PREFERRED PROJECT REPORT

d'Albora Marinas – The Spit (MP08_0046)

Project No.: 2006-038
Project Address: Spit Road, The Spit, NSW
Local Government Area: Mosman
Client: Ardent Leisure
Report Reference: 2006-038 Preferred Project Report (v2) - Final
Prepared By: Benjamin Cribb
Reviewed By: Kristy Lee
Final Approval:

Date: 07 October 2011

Figure 6: Plan illustrating proposed amendments to marina (indicated in orange) and land based works including new hardstand area and modified car parking (Source: Proponent's PPR)

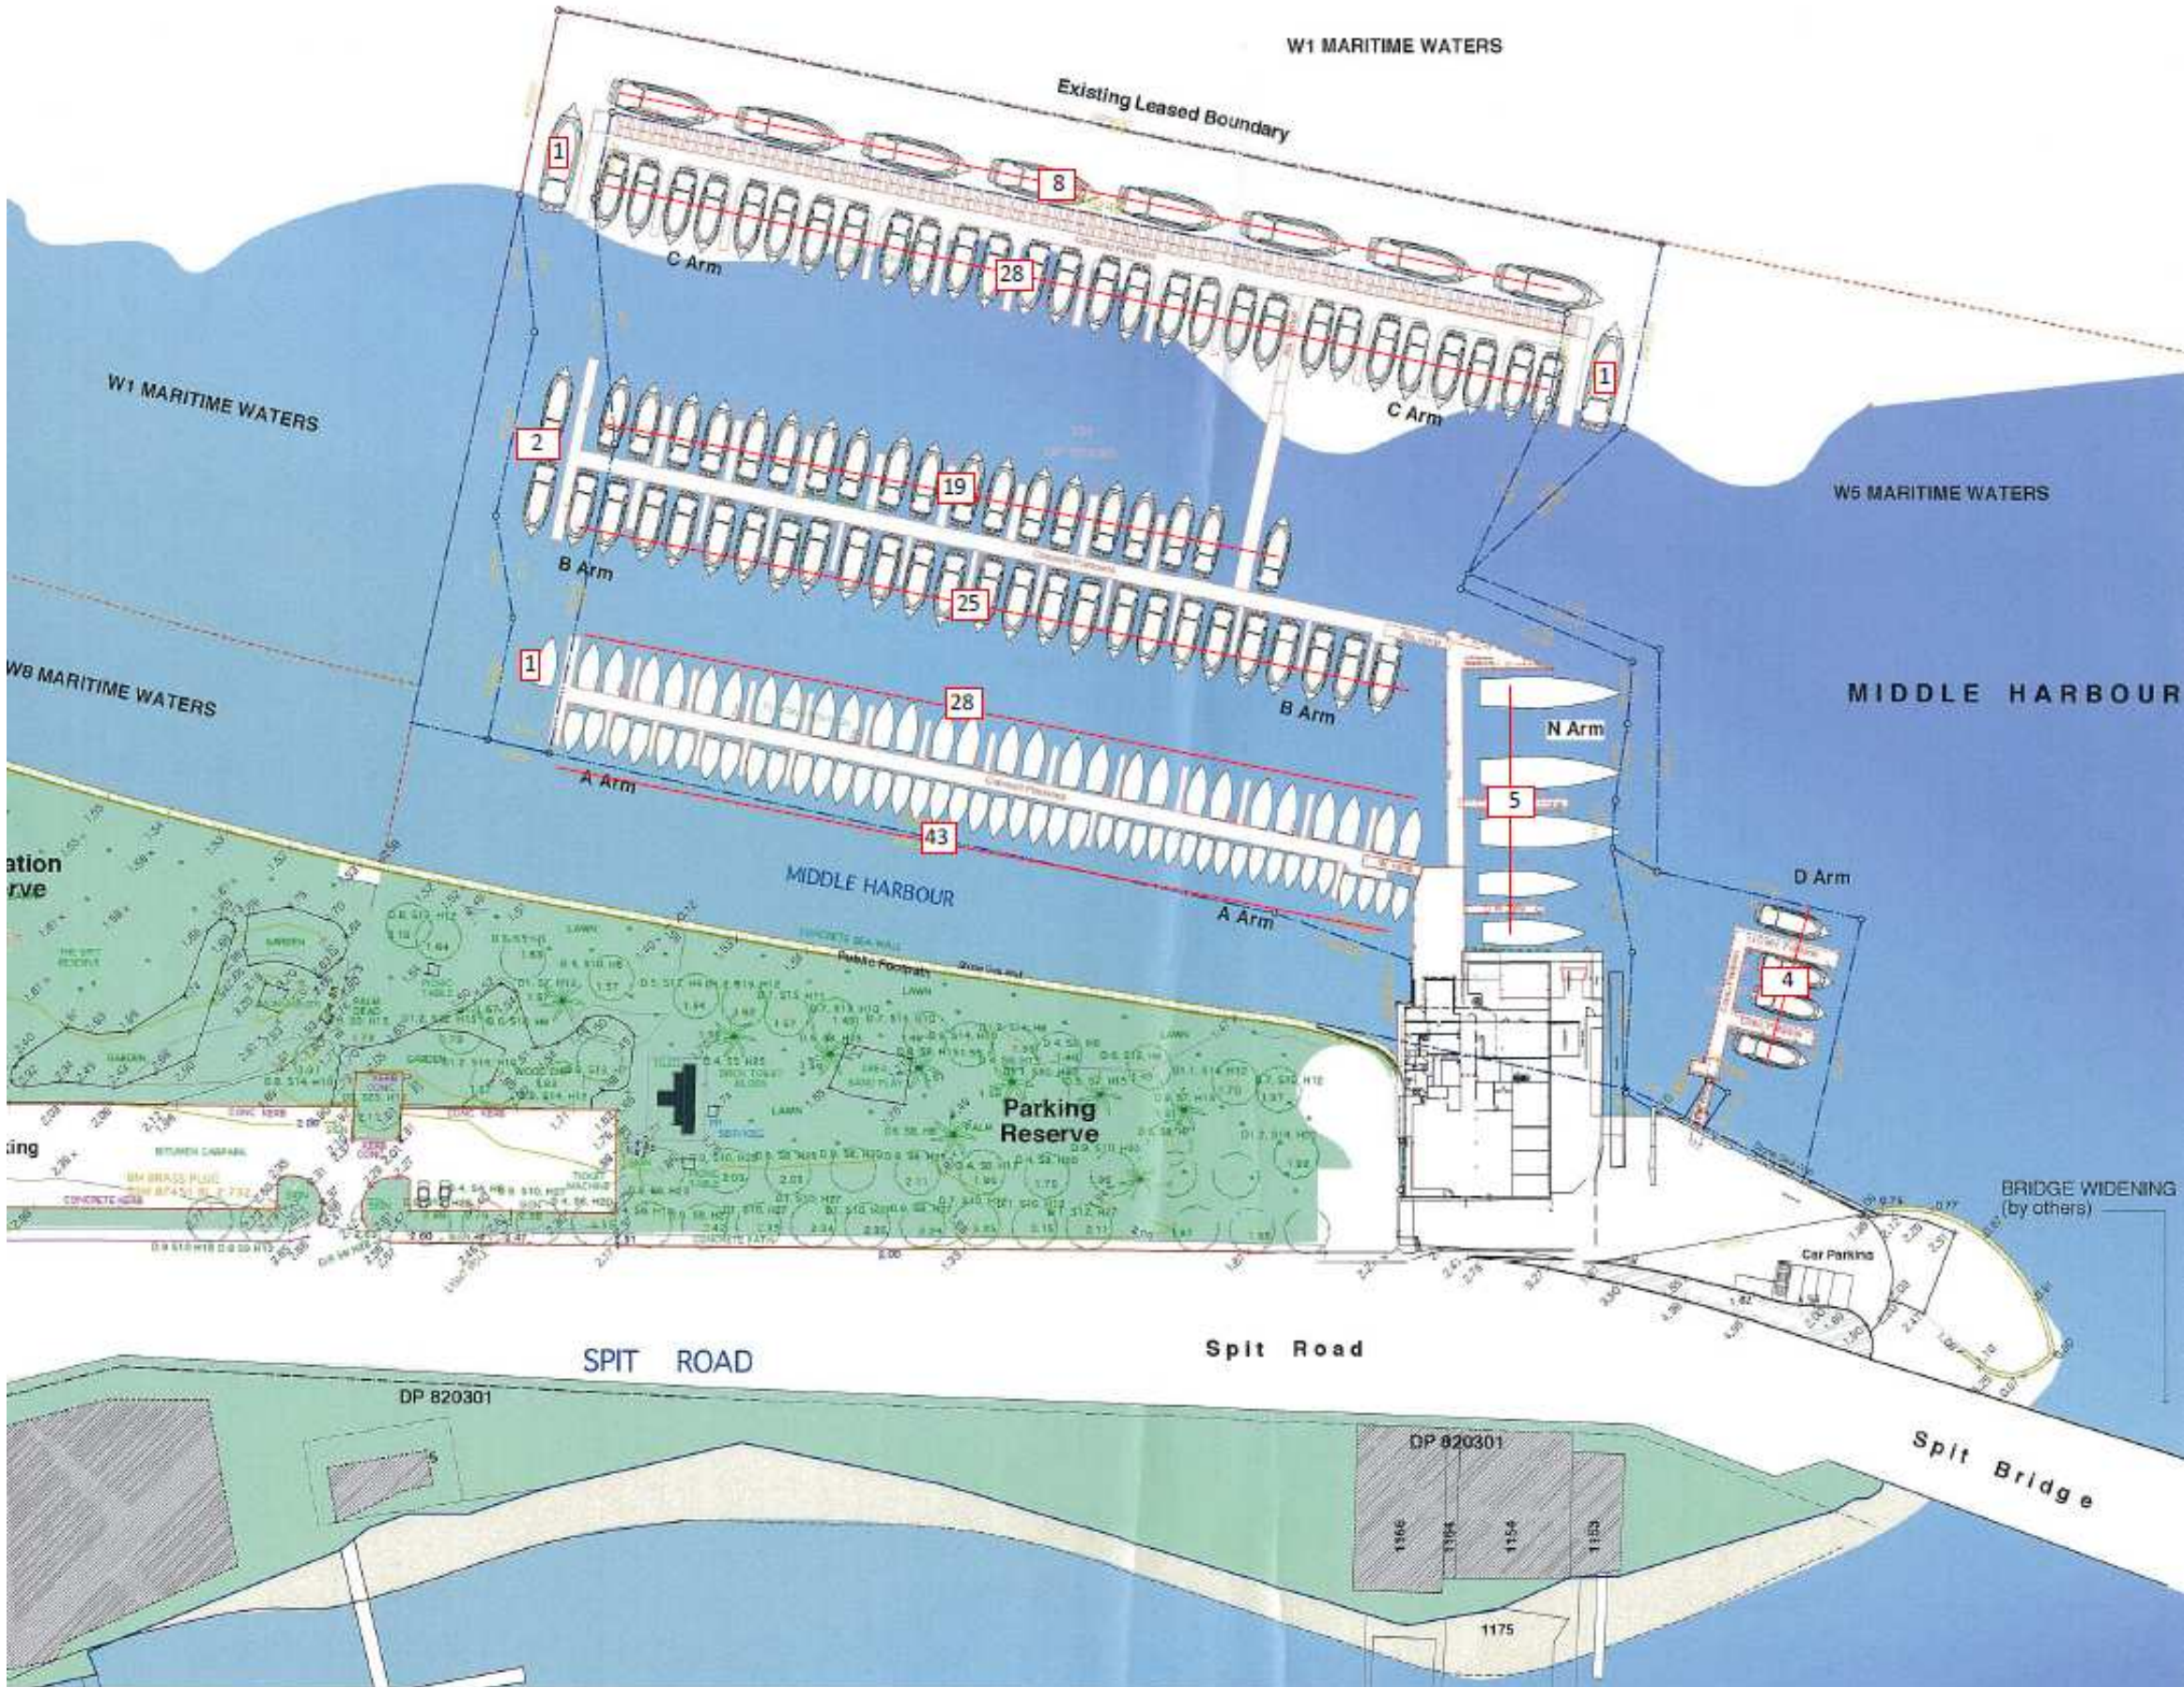
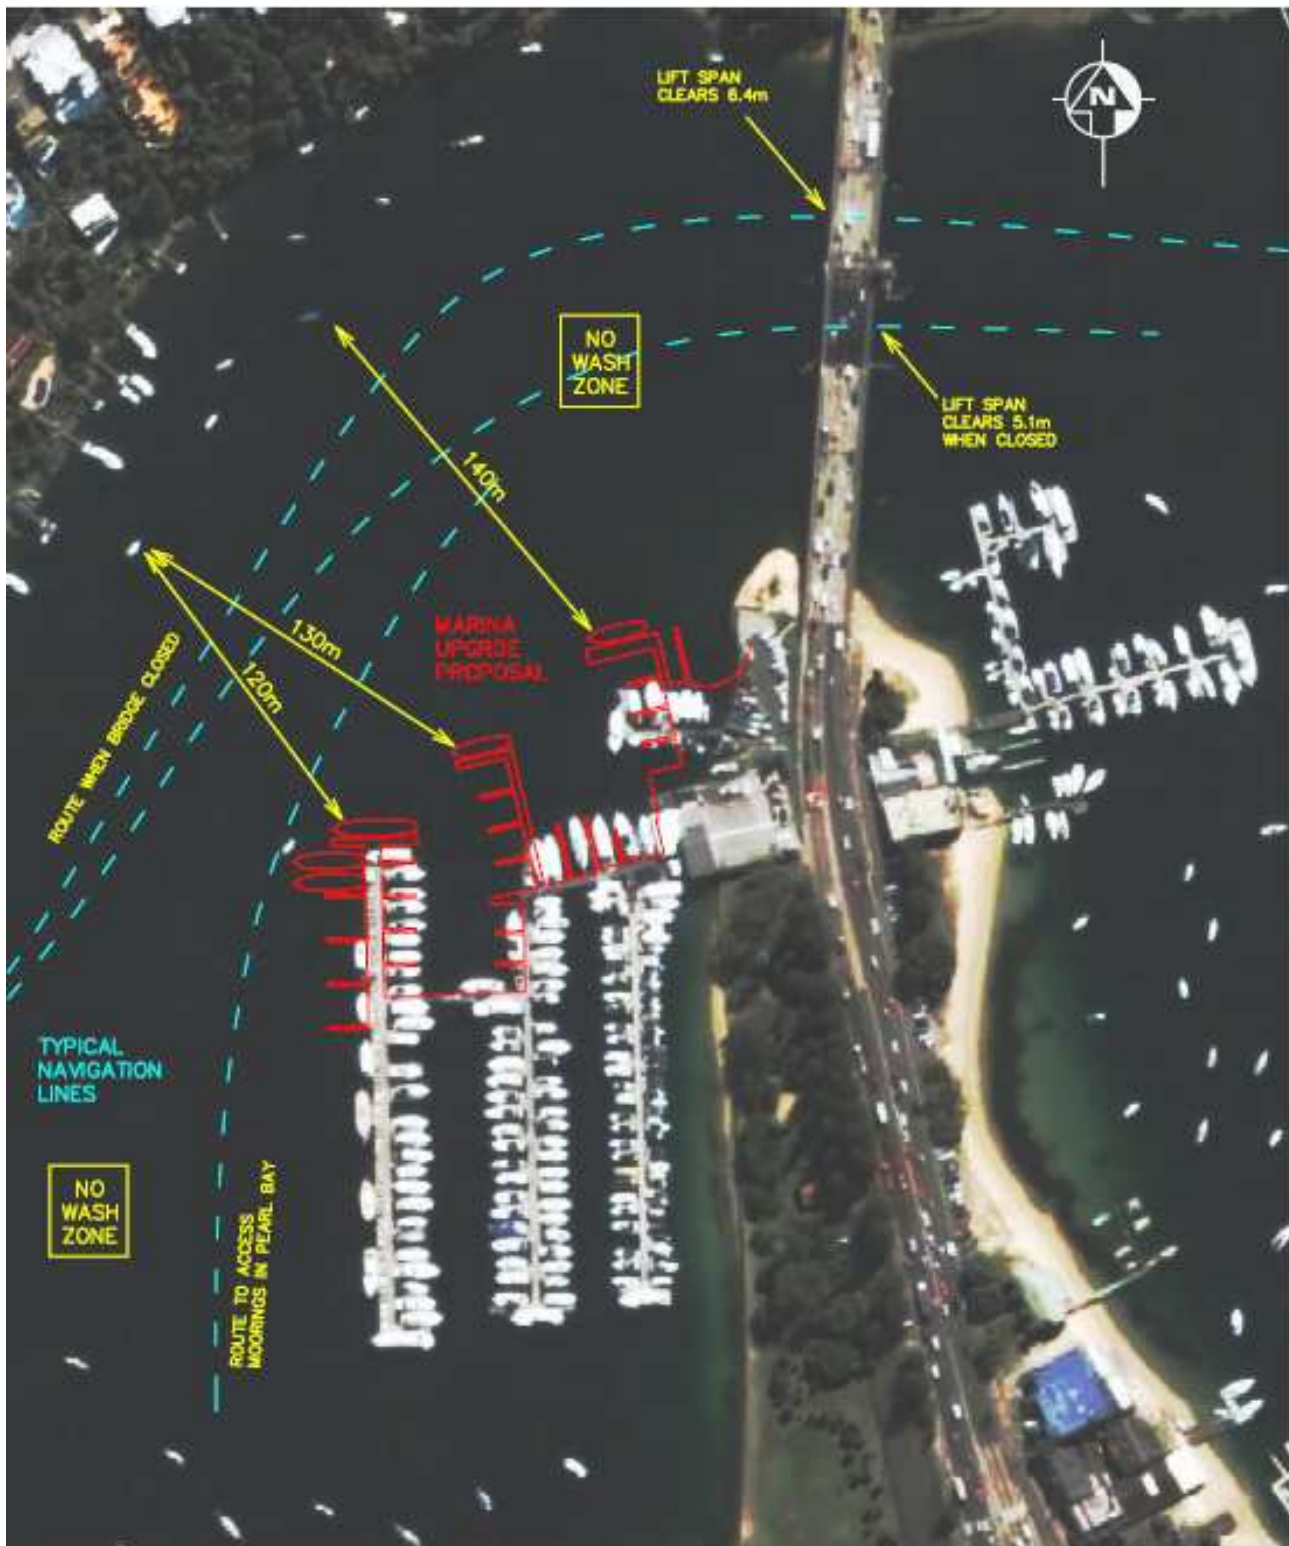
6. There does not appear to be wide enough fairway for 30m boats to enter Arm N inner and Arm D (between the walkway at the northern end of Arm D and vessel 179). The fairway appears to be approximately 38m wide compared with 45m required by AS 3962.

7. There appears to be insufficient fairway width at the entrance to Arm C inner and Arm B outer. The east-west arm at the southern end of Arm B seems to extend a little too far on drawing DA01 Rev Q. A fairway width of 16.5m is required by AS 3962 but it appears there is only 15m on DA01 Rev Q.

The distance between berth 179 and the fuel and sewerage services area (northern end of Arm D) is approximately 38 metres. The distance required under AS 3962 is not required as Arm D and Arm N are not opposite each other and do not constitute a fairway.

The proposed distance is sufficient for access by the proposed vessels and is not therefore a navigation issue.

The entrance to Arm C inner and Arm B is 22.75 metres and complies with AS 3962.
